Two storey front extension.
61 Queens Fields West Aldwick

Thank you for your internet representation made on 19th February 2020 which has been recorded as '**an objection**' with the comments as follows:

sheet 2 of 3

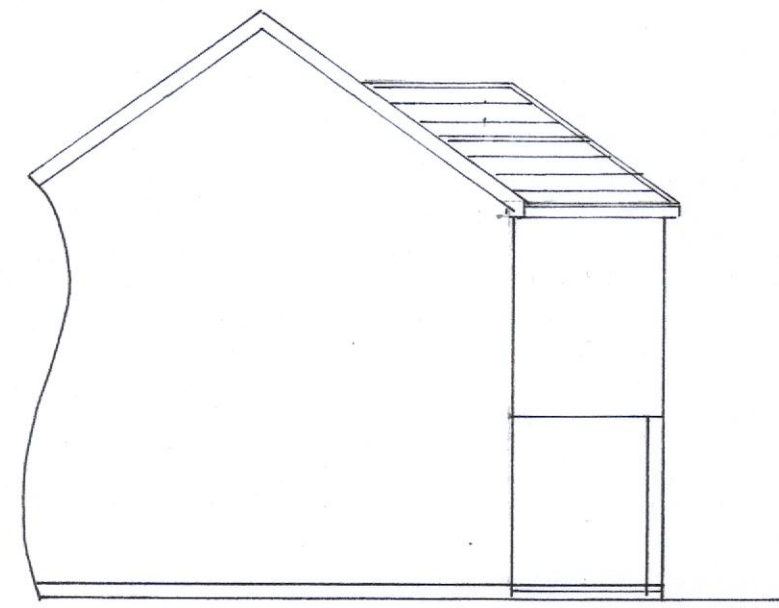
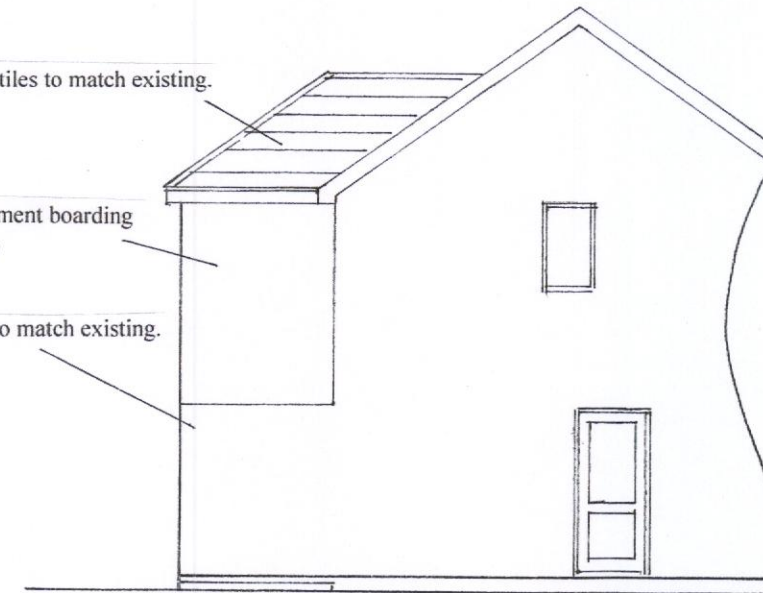
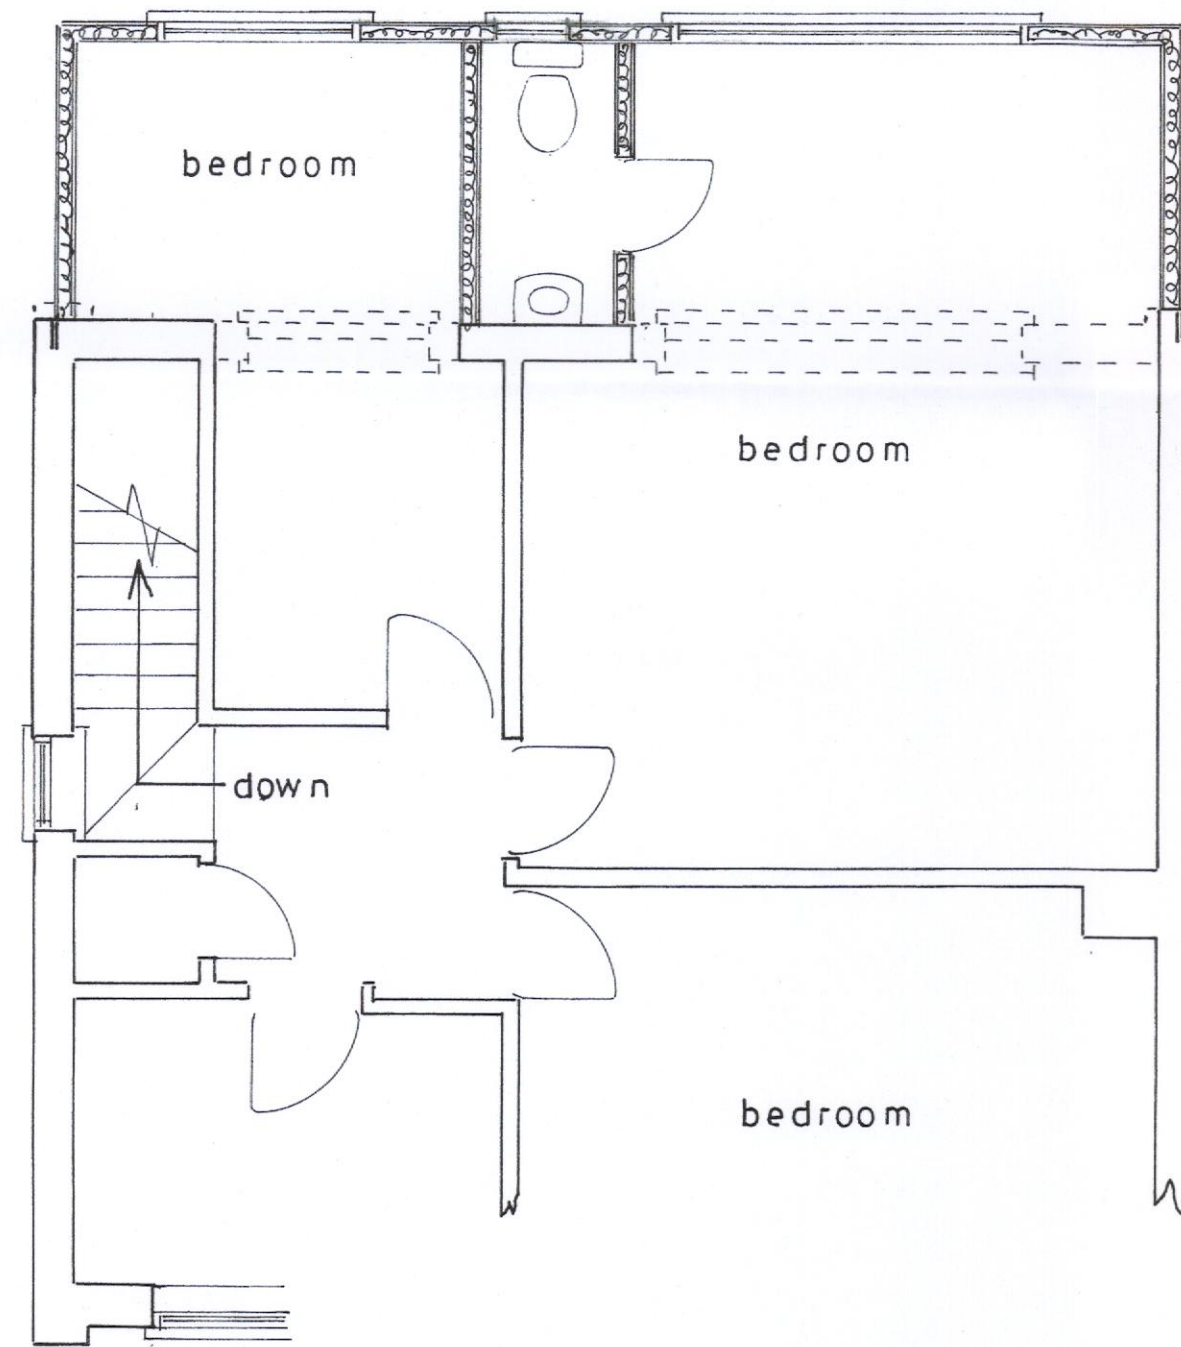
Members strongly objected to the proposed application on the grounds that : it does not .. reflect the characteristics of the site and local area in its layout, landscaping, density, mix and scale and because the extension does not sympathetically relate to and is not visually integrated with the existing building in siting massing design form and scale and because the extension is not visually subservient to the main building and because it has an adverse overshadowing overlooking and overbearing effect on neighbouring properties and because it compromises the the established character and pattern of the place. Therefore Members agreed that the application is in direct conflict with Policies DSPI (a), DDM4 a, b,c and e of the Arun Local Plan 2011-2031 and with the Parish Design Statement (page 71 (a).
